Recommendation Report for Planning Permission for Works or Extension to a Dwelling

REF NO: M/26/15/HH

LOCATION: 1 West Avenue
Middleton on Sea

PROPOSAL: Demolition of rear conservatory with new rear extension.

Drawing 3 / 5

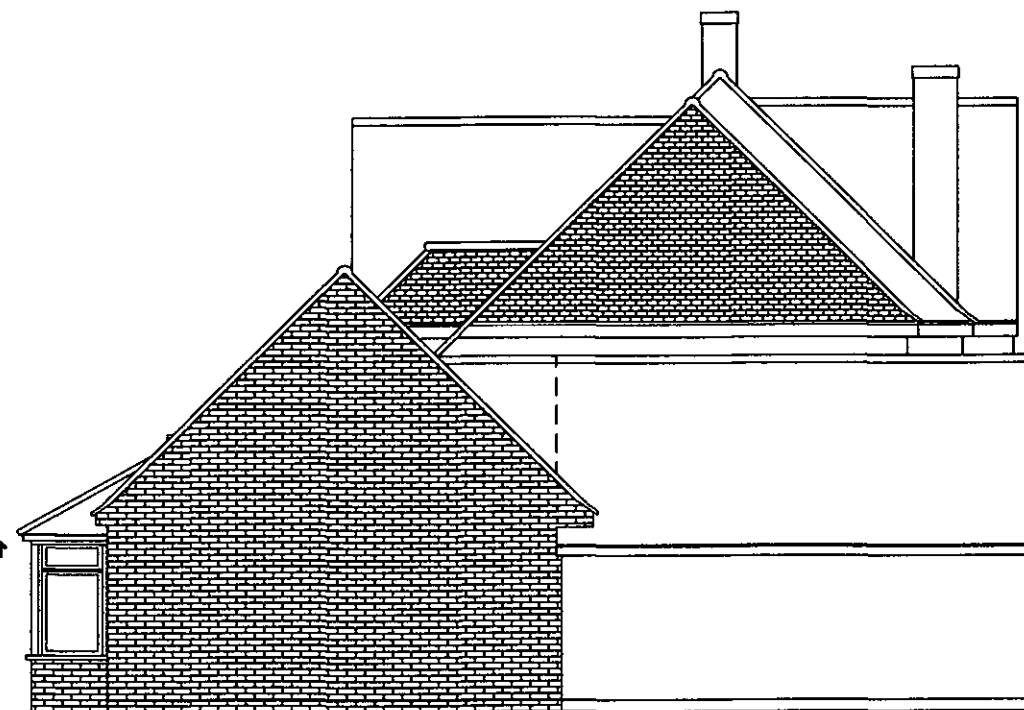
The proposed single storey extension to the rear of the existing garage measures 6 metres in height, 1.2 metre higher than the existing ridge height of the garage. The considerable height of the proposed extension (to the rear of the garage) is considered to be overly dominant within the street scene and actively competes with the host dwelling and as such is not considered to be subservient to the host dwelling in conflict with policy DEV19 (ii). The bulk of the roof when viewed from the north and the large expansive eastern elevation is also considered to be incongruous and out of character with the host dwelling in conflict with GEN7 (ii) and DEV19 (i) of the Arun Local Plan.

The proposed extension (to the rear of the existing garage) due to its location 0.85m from the eastern boundary and its height of approximately 6 metres with a depth of up to 6.5 metres is considered to have an unacceptable overbearing effect on the occupiers of 11a Harefield Road in conflict with policies GEN7 (iv) and DEV19 (iii).

- 1 The proposed rear extension by reason of its size and location is not considered to be subservient to the host property resulting in an unacceptable impact on the character and appearance of the dwelling and that of the wider locality. The proposal therefore conflicts with policies GEN7 and DEV19 of the Arun District Local Plan and paragraph 64 of the National Planning Policy Framework.

- 2 The proposed rear extension due to its position, bulk and proximity to the western boundary will have an unacceptable overbearing impact upon the neighbouring property, 11a Harefield Road, in conflict with policies GEN7 and DEV19 of the Arun District Local Plan and the National Planning Policy Framework.

Scale:	1:100 1:500
Date:	29th September 2013
Drawn by:	
Drawing 1 / 5

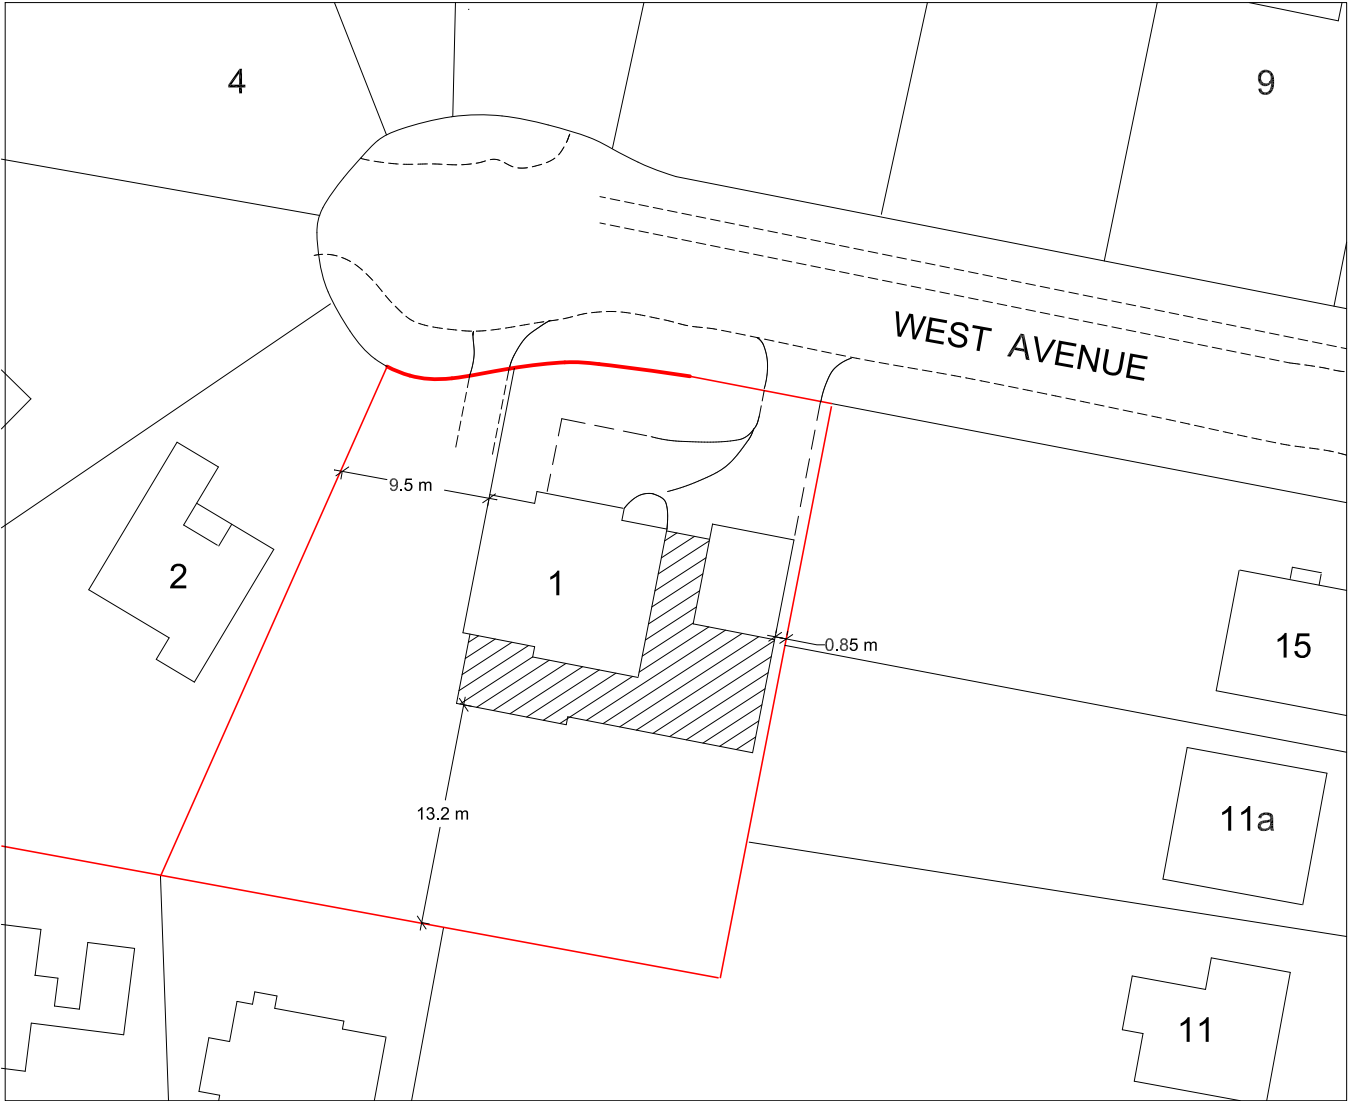
The Applicant has shown on his drawing 1/5 an access for which he knows he is not legally possible to use - under his present deeds.

Our Estate plan clearly shows that there is NO ACCESS IN THE POSITION SHOWN ON HIS DRAWING 1/5

Therefore the Applicants drawing is incorrect and misleading

There is a new vehicle access commenced from the private road shown on drawing 1/5 which is not legal. The applicant has clearly misled the Planning Authority to suggest there the access driveway is not new.

* The application does not seek permission for the creation of a secondary access into the site and due to the class of the road planning permission would not be required for these works. Therefore, the concerns in relation to the secondary access is a civil matter and if covered by the property deeds would need to be pursued privately outside of the planning system.
